Application No: WA/32/21/PL
Site Address: Land at West Walberton Lane Walberton BN18 0QF
Description of works: Construction of 30 No. dwellings together with associated access, parking, public open space & landscaping. This site may affect the setting of listed buildings, affects the character & appearance of the Walberton Green Conservation Area, is a Departure from the Development Plan & is in CIL Zone 3 & is CIL Liable as new dwellings.

Thank you for your internet representation made on 14th May 2021 which has been recorded as an objection with the comments as follows:

House Type 3BH3

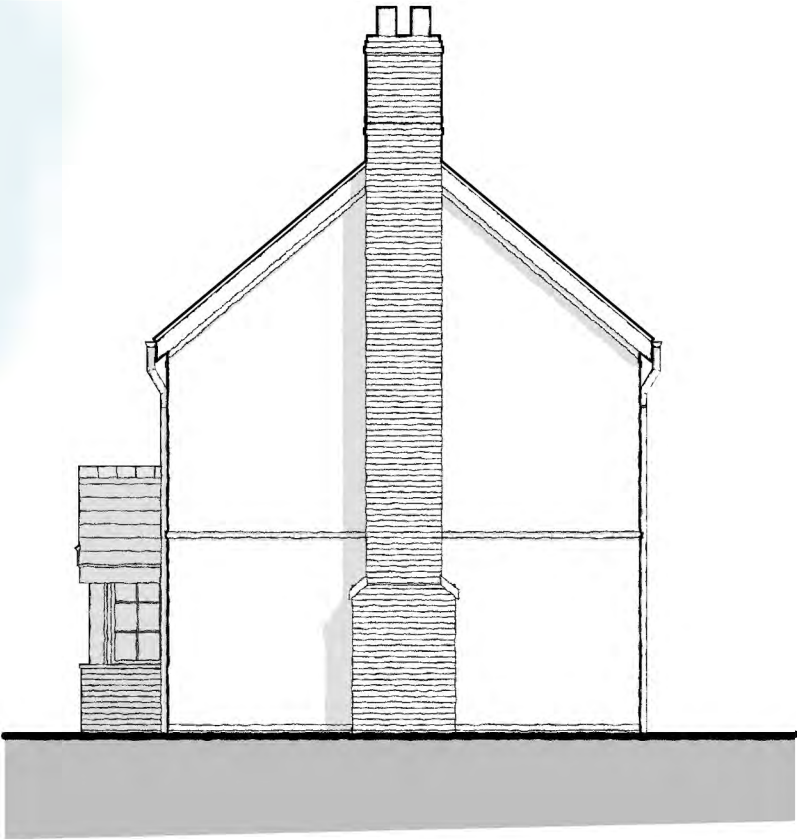
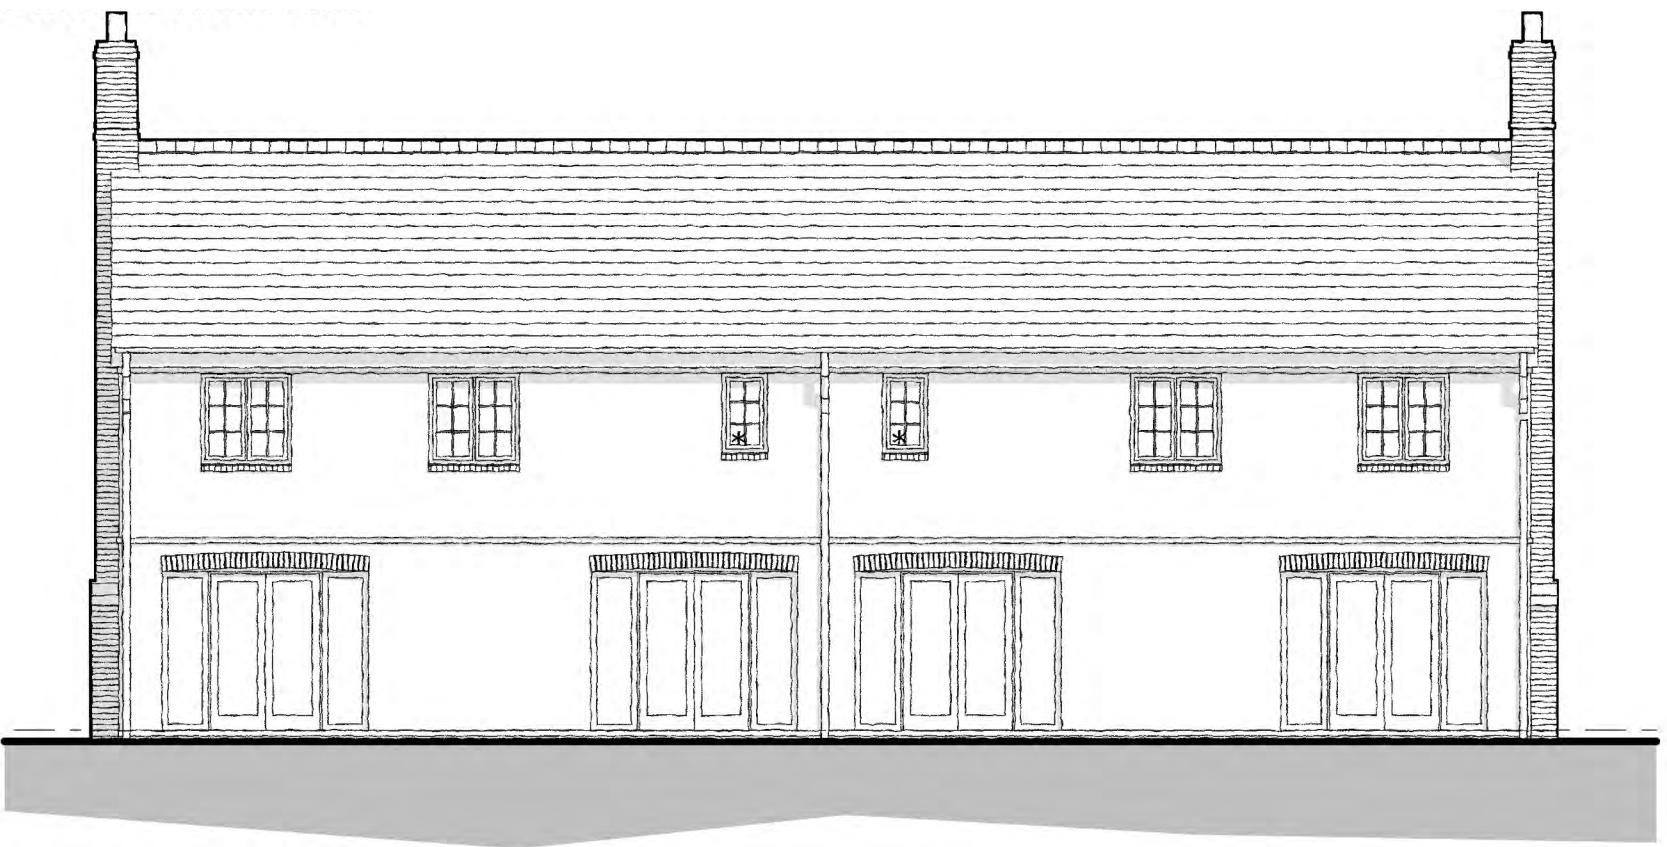
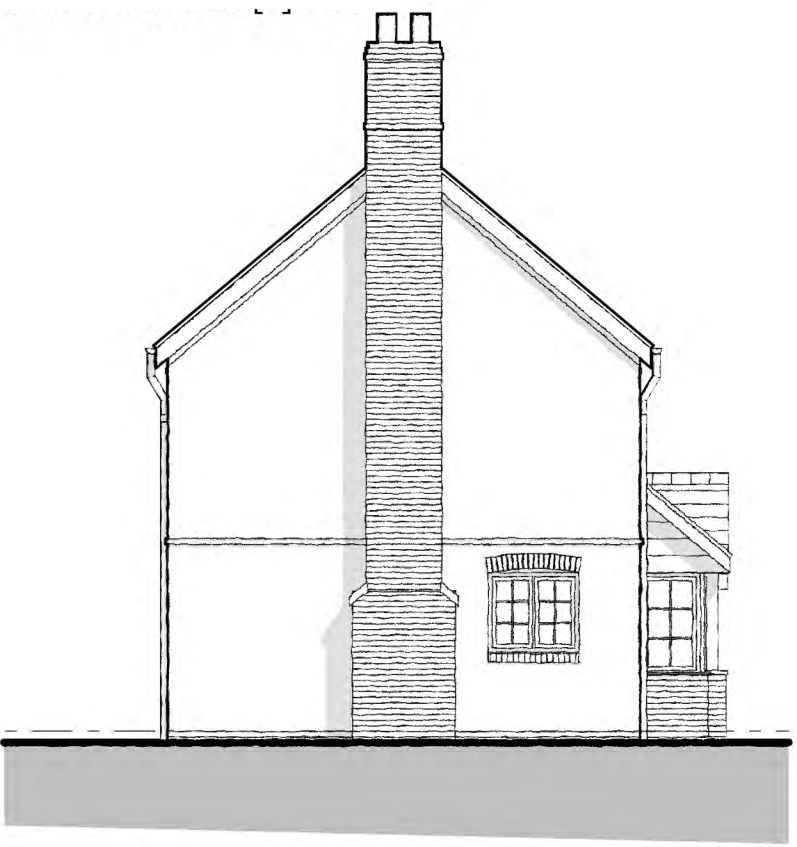
3. The site has been rejected for development by the Neighbourhood Plan, which has been approved by 91% of those voting.
4. The site violates the protected view of the Village Green in the Neighbourhood Plan. The new houses, on two floors plus high pitched roofs, will dominate the low-rise buildings surrounding them.

7. The design of the buildings is garish and clashes with the existing surrounding buildings.
